Rezoning Transportation Analysis

Petition Number: 2023-017

Date	Description
06-28-23	First Review (PDM)
10-25-23	Second Review (JP)

Rezoning Plan

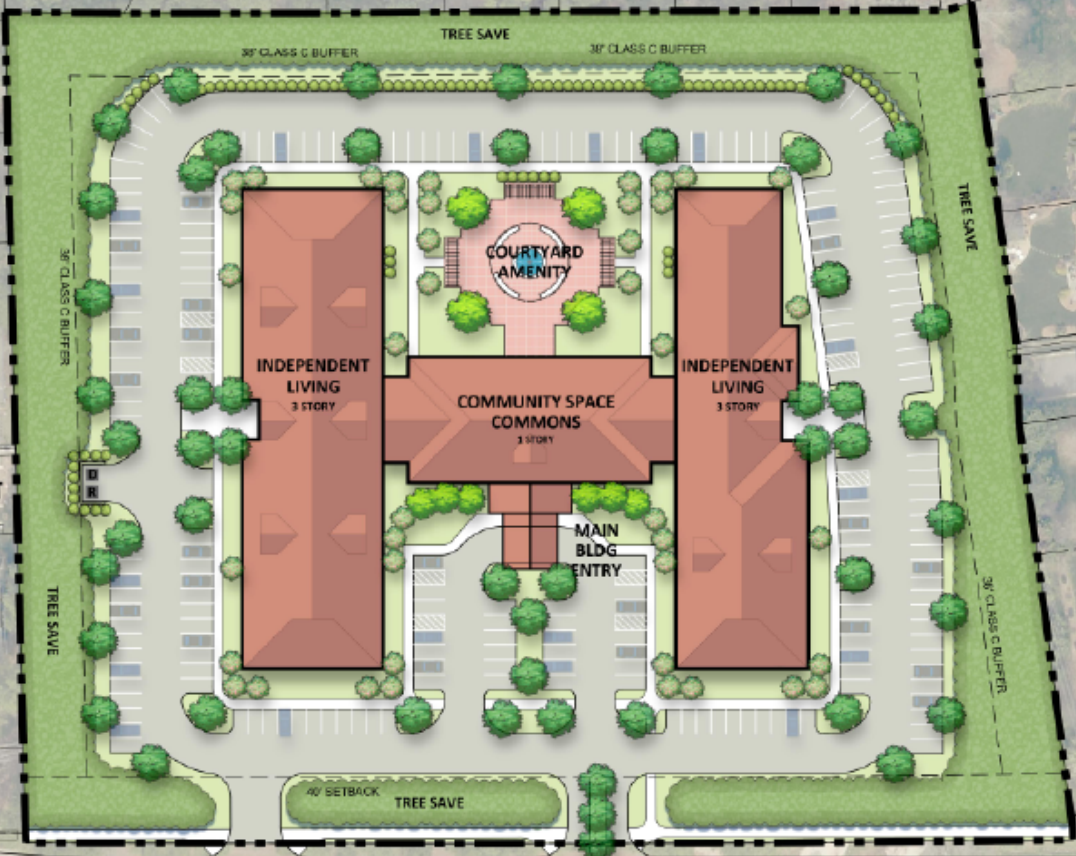
13. **New Comment 10.25.2023** – Revise proposed intersection improvements to construct matching short westbound left turn lane at location of full access driveway and newly constructed eastbound left turn lane.
